The Planning Inspectorate
Outer Dowsing Offshore Wind Project

My response to ExQ1 – Q1 TT 14

Construction Traffic Effects

Drawing Title: LOCATION 011 - MILLFIELD LANE EAST / LOW ROAD / STREETWAY / WYBERTON ROADS - INDICATIVE PASSING PLACES

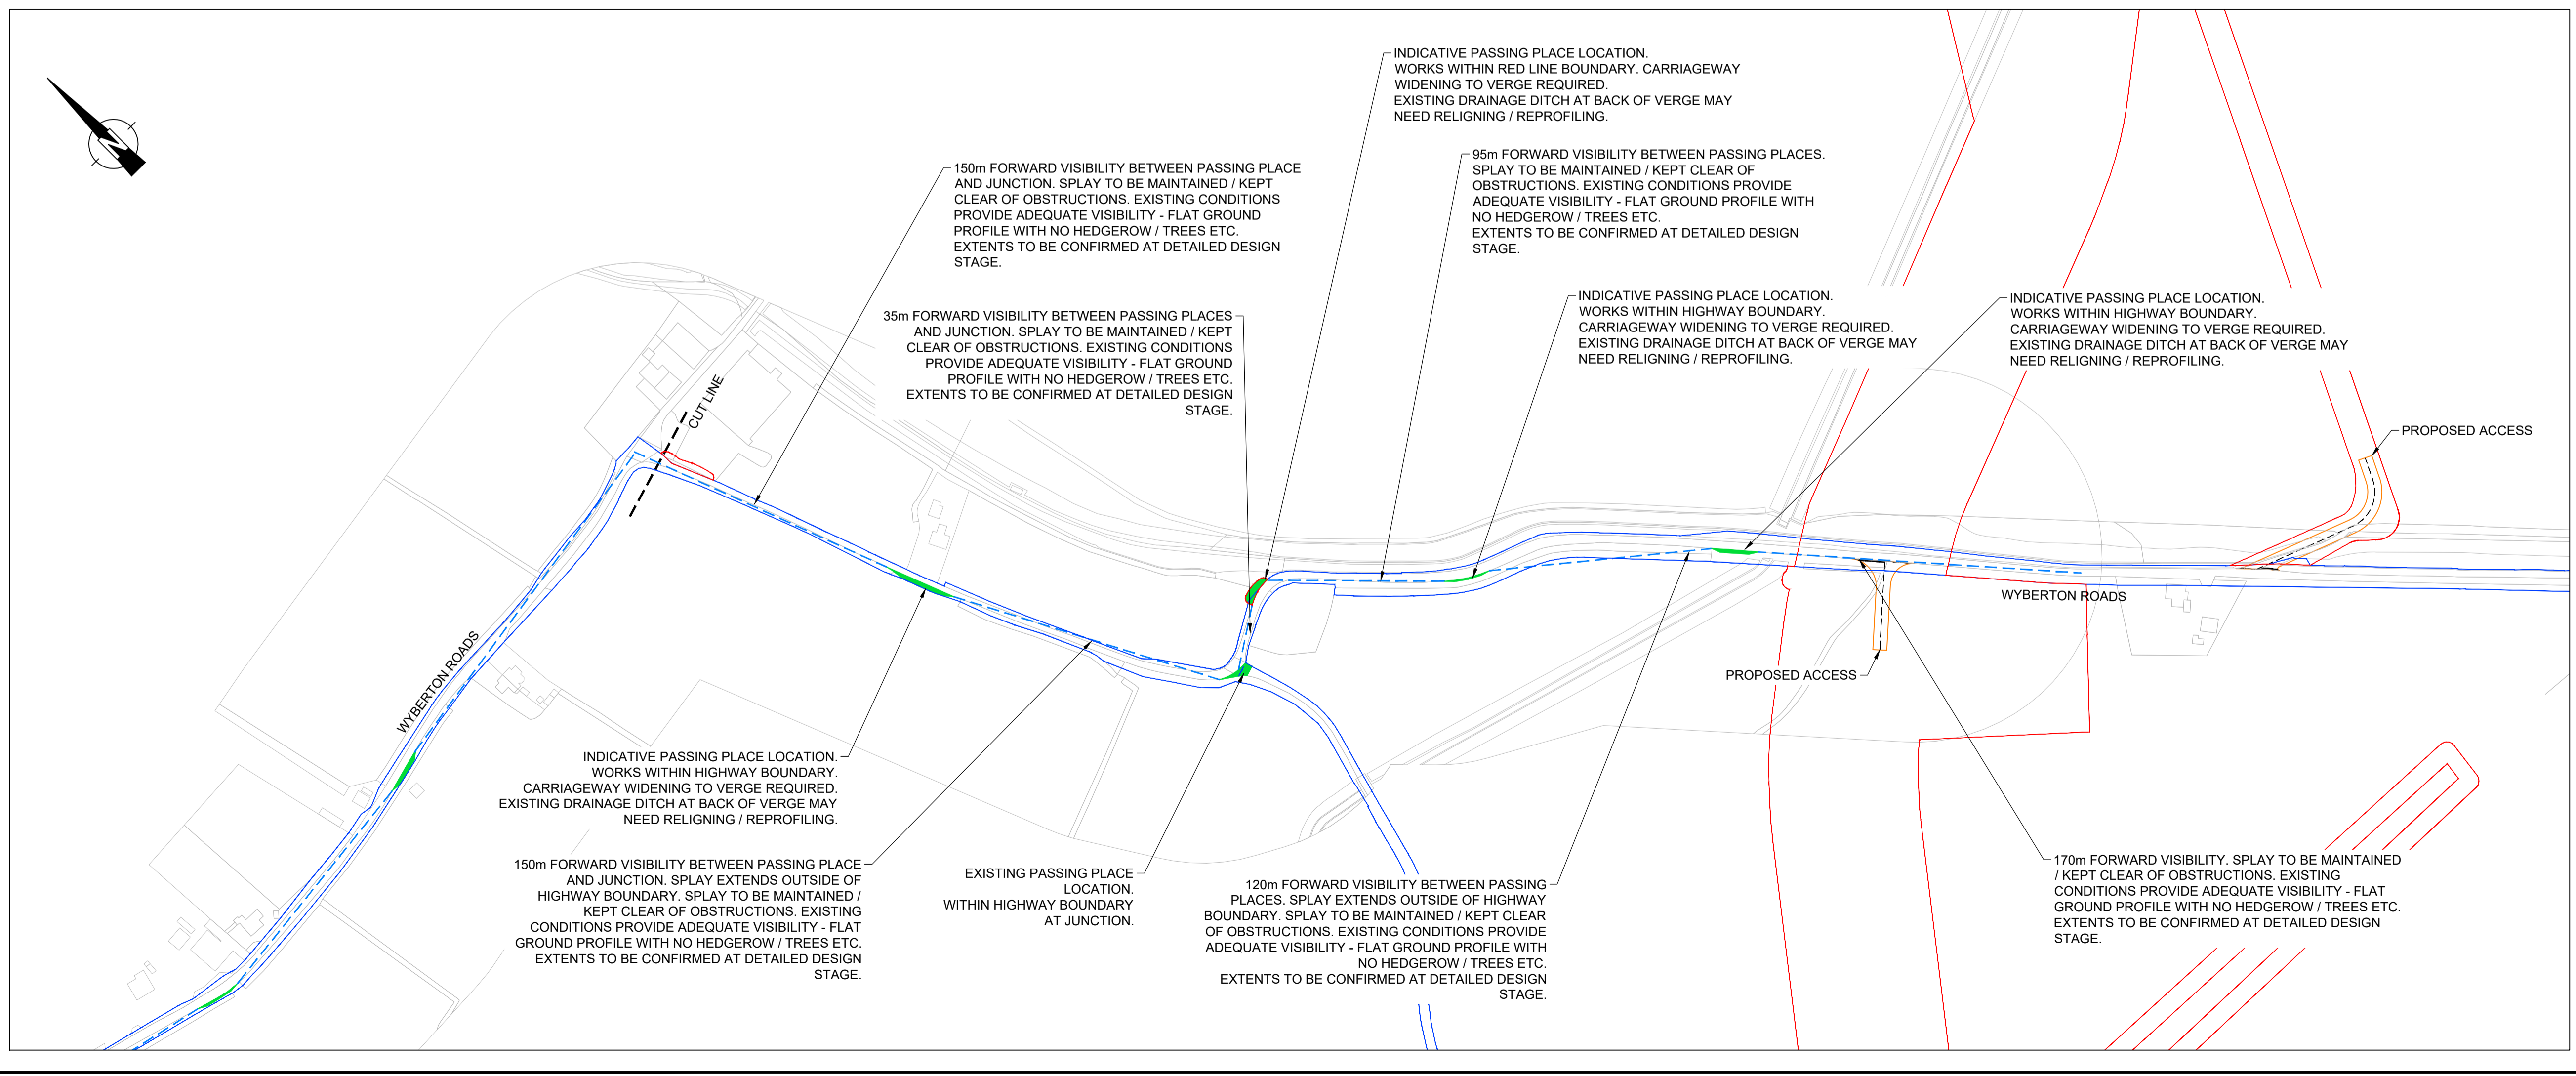
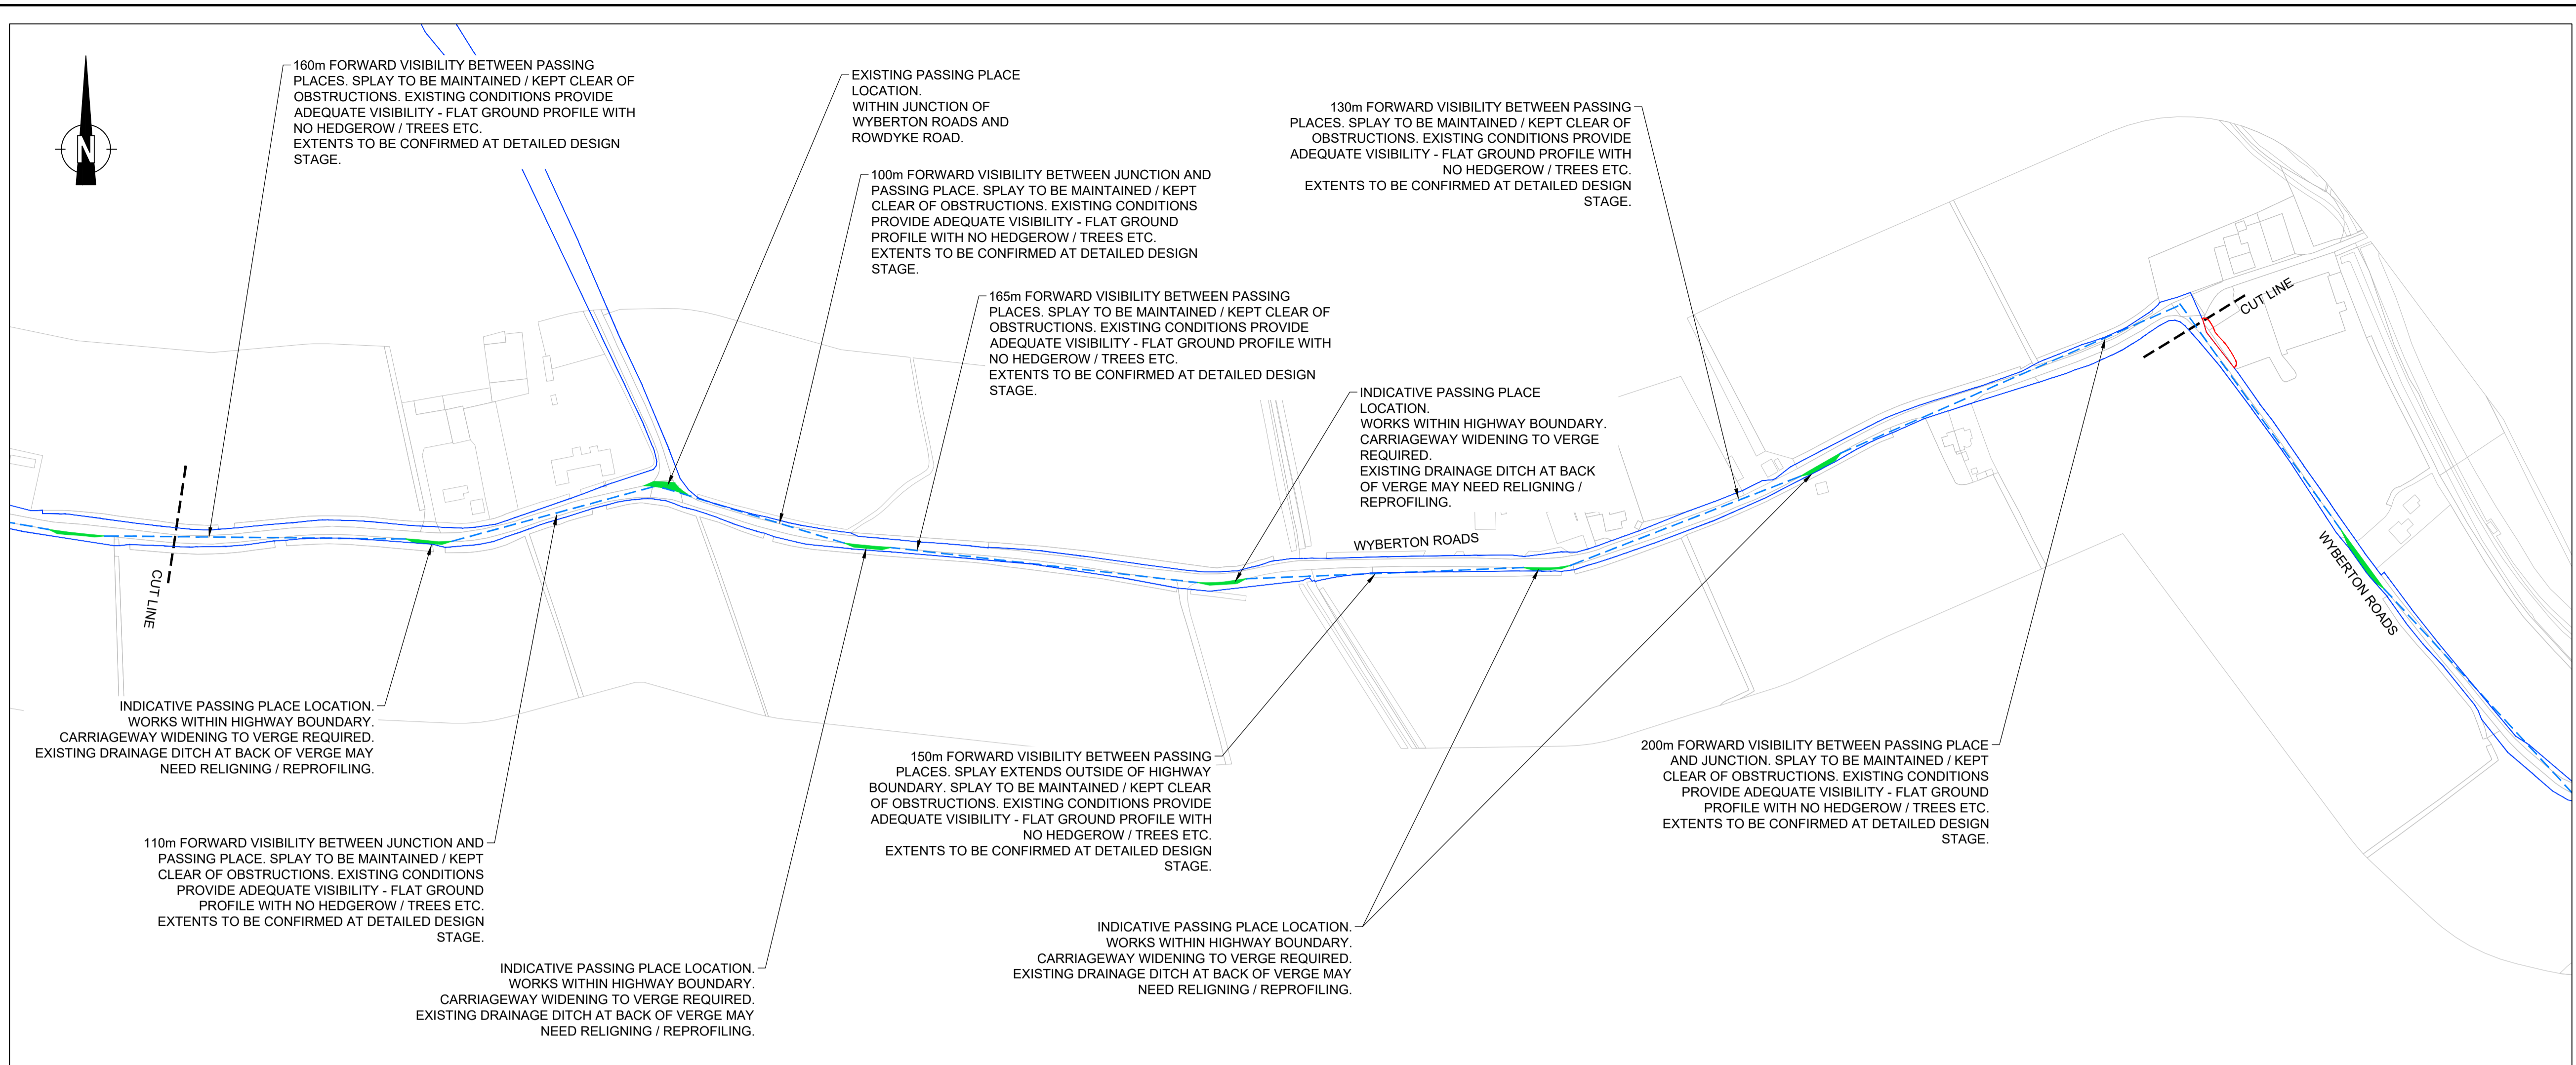
- The (primarily) HGV traffic assessment for Wyberton Roads seem to have been assessed as “reasonable”. However, as the map at the end of this letter notes several sections that plan to be used are incapable of having cars & HGVs being able to pass each other.

- Vehicles in most places would have to mount grass verges to pass, and in some places even this would not allow vehicles to pass one another – in poor weather verges would be muddy and vehicles could get stuck.

- There is a blind double bend close to the White House access road which will be a bottleneck and would require one of the vehicles to reverse if meeting another one.

- Wyberton Roads is one of only two routes to Frampton Marsh Nature Reserve, and traffic varies considerably e.g. seasons, weather, school holidays, spotting of rare birds etc. – I doubt that the traffic assessment takes this into account. Adding 77 traffic movements daily is significant i.e. over 9 additional vehicle movements per hour in an 8-hour working day.

- From a selfish perspective, exiting from my driveway will be more difficult, and potentially more dangerous, than currently due to the increased volume of traffic and size of vehicles using the road. The exit is effectively blind and requires slow exit to allow passing vehicles to spot a car exiting my property.
